HYDRANT CONDITION CONSULTATION WITH PLANNING AUTHORITY

Planning Ref: A/3/21/PL

Address: Pound Place, Roundstone Lane, Angmering, BN16 4AL

Description: Erection of a 74-bed care home (C2 residential institution) with car parking, landscaped gardens & access from Roundstone Lane. (resubmission following A/9/19/PL). This site is in CIL Zone 2 (Zero Rated) as other development.

Drawing Site Layout
General Arrangement

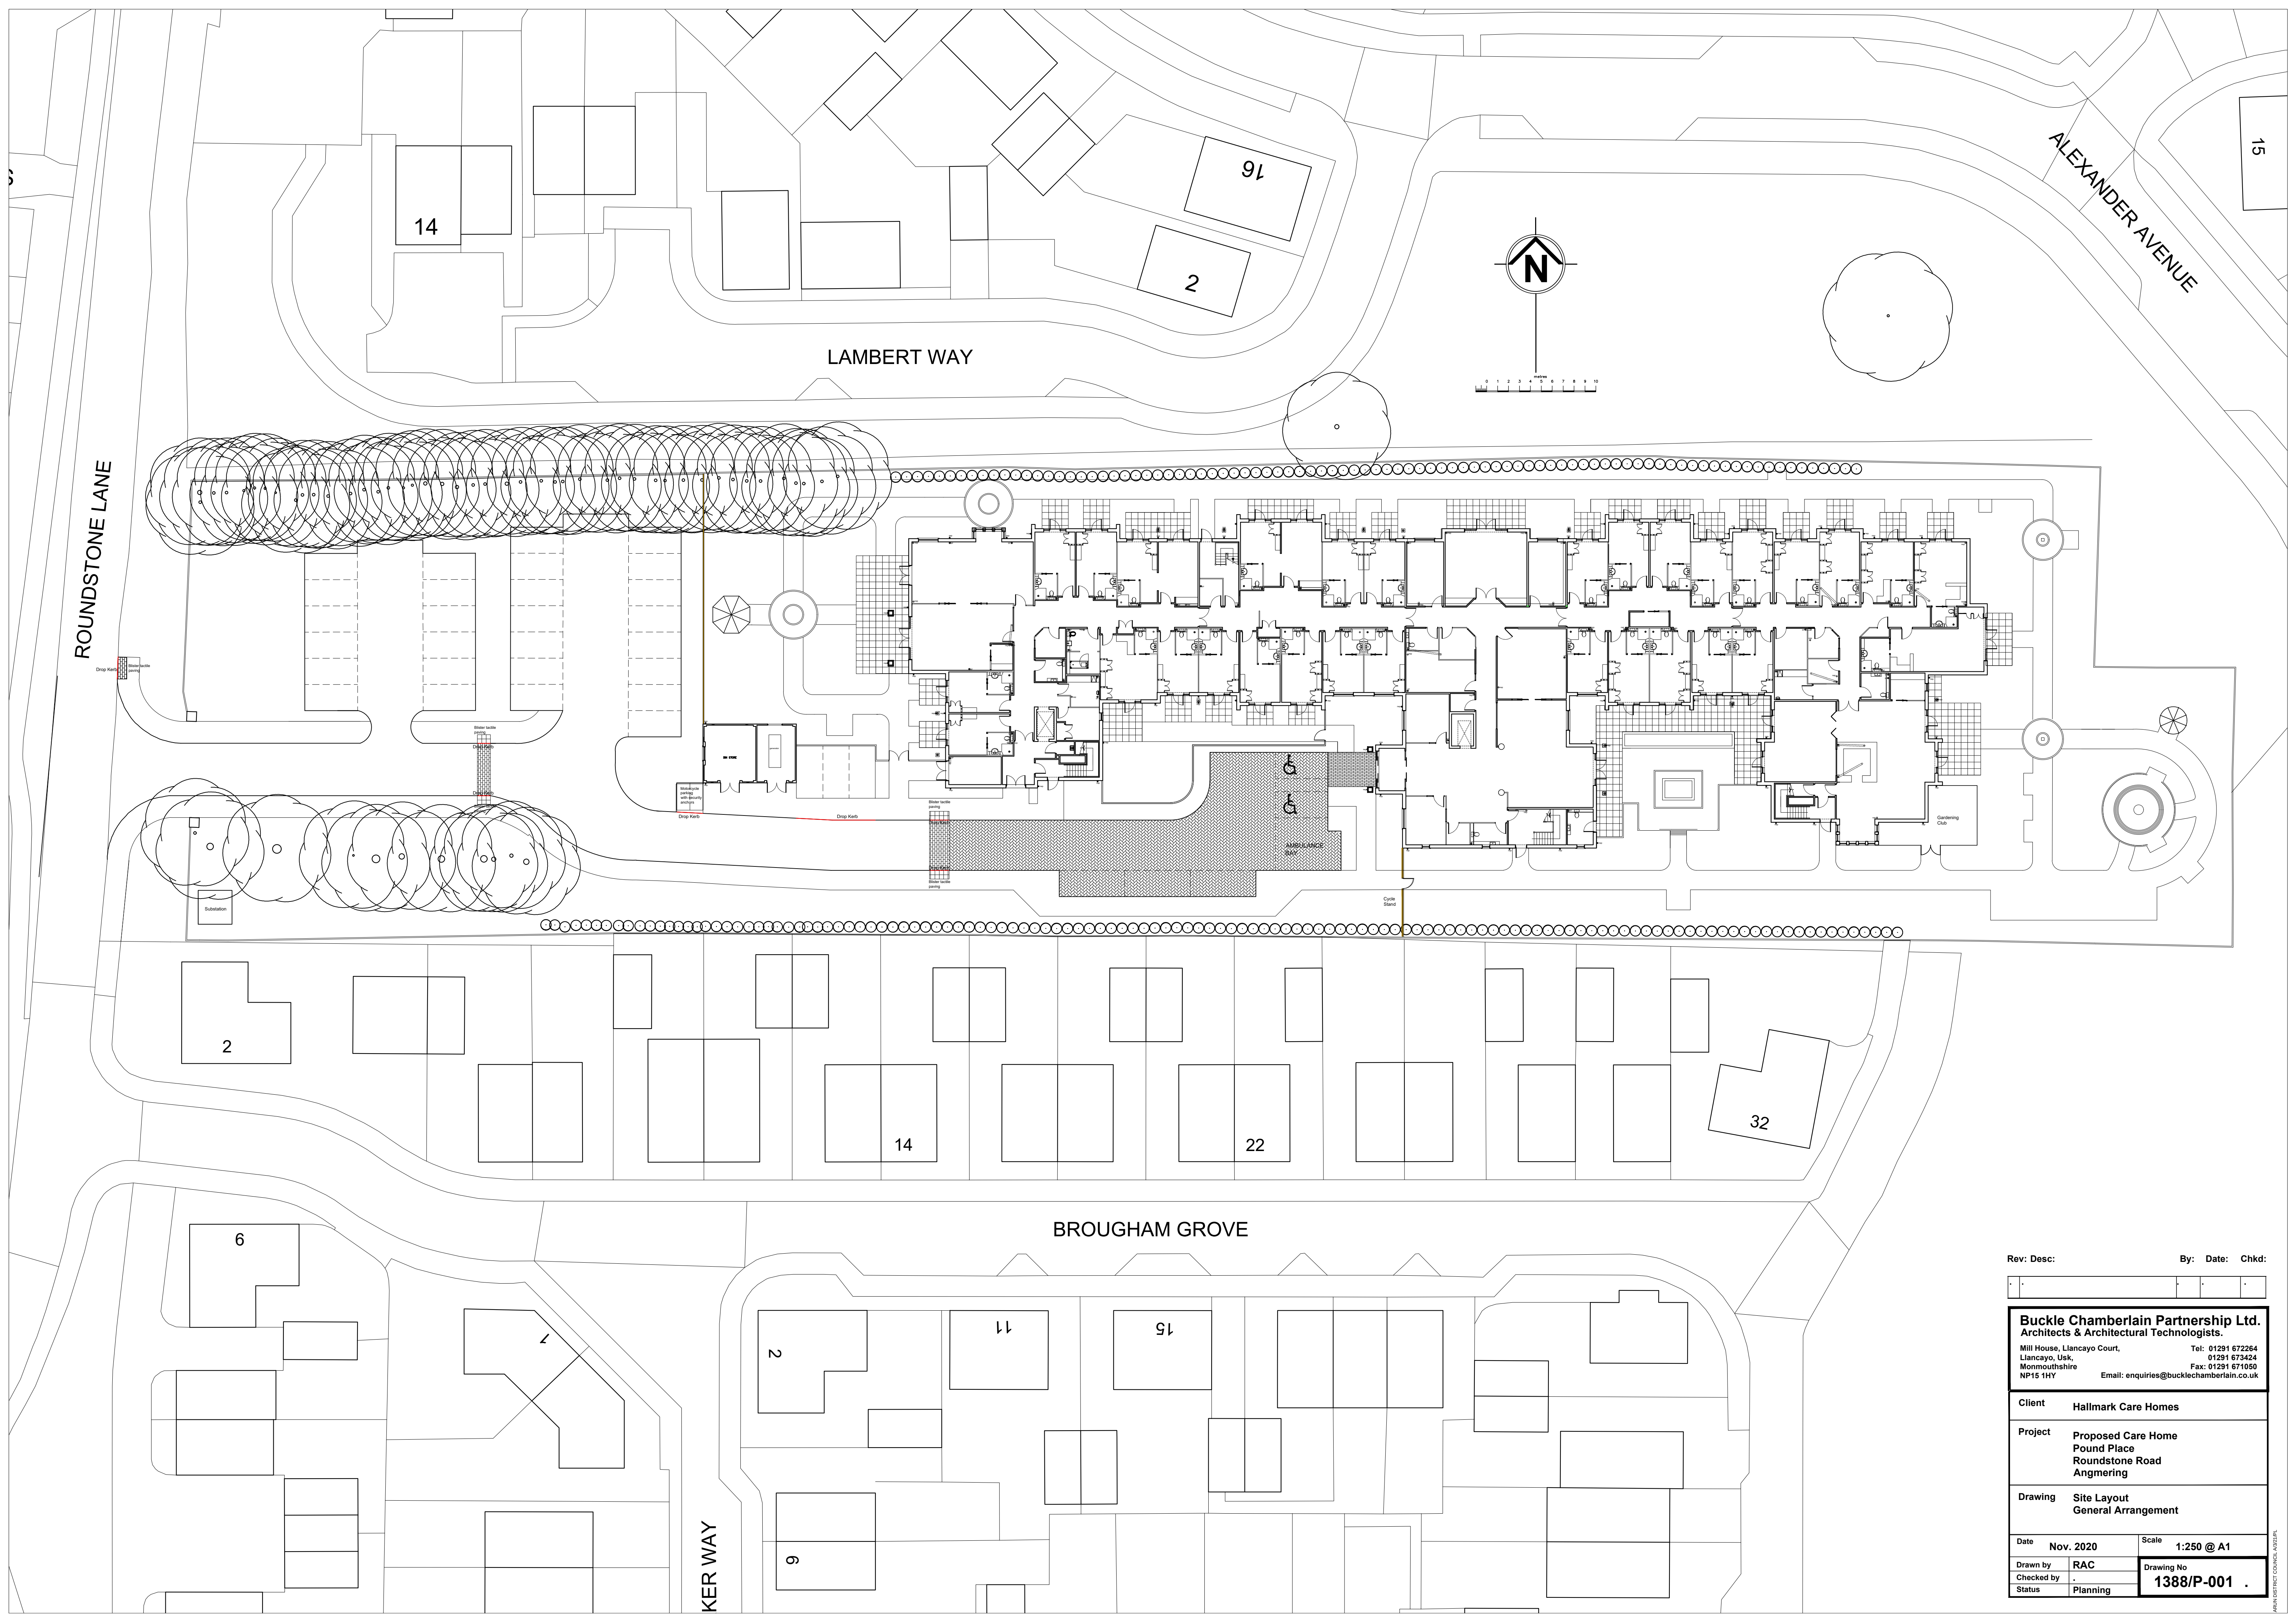
Please find attached a planning condition for application no. A/3/21/PL for the requirement of an additional fire hydrant. Currently the nearest Hydrant to these proposed properties is 150 metres away. The supply of water for firefighting for a commercial premises should be within 90 metres.

Evidence will also be required that Fire Service vehicle access meets with the requirements identified in Approved Document B Volume 1 2019 Edition: B5 Section 13, including Table 13.1 and diagram 13.1.

- 1) Prior to the commencement of the development details showing the proposed location of [1] one fire hydrant or stored water supply (in accordance with the West Sussex Fire and Rescue Guidance Notes) shall be submitted to and approved in writing by the Local Planning Authority in consultation with West Sussex County Council's Fire and Rescue Service. These approvals shall not be unreasonably withheld or delayed.
- 2) Prior to the first occupation of any dwelling/unit forming part of the proposed development that they will at their own expense install the fire hydrant (or in a phased programme if a large development) in the approved location to BS 750 standards or stored water supply and arrange for their connection to a water supply which is appropriate in terms of both pressure and volume for the purposes of firefighting.
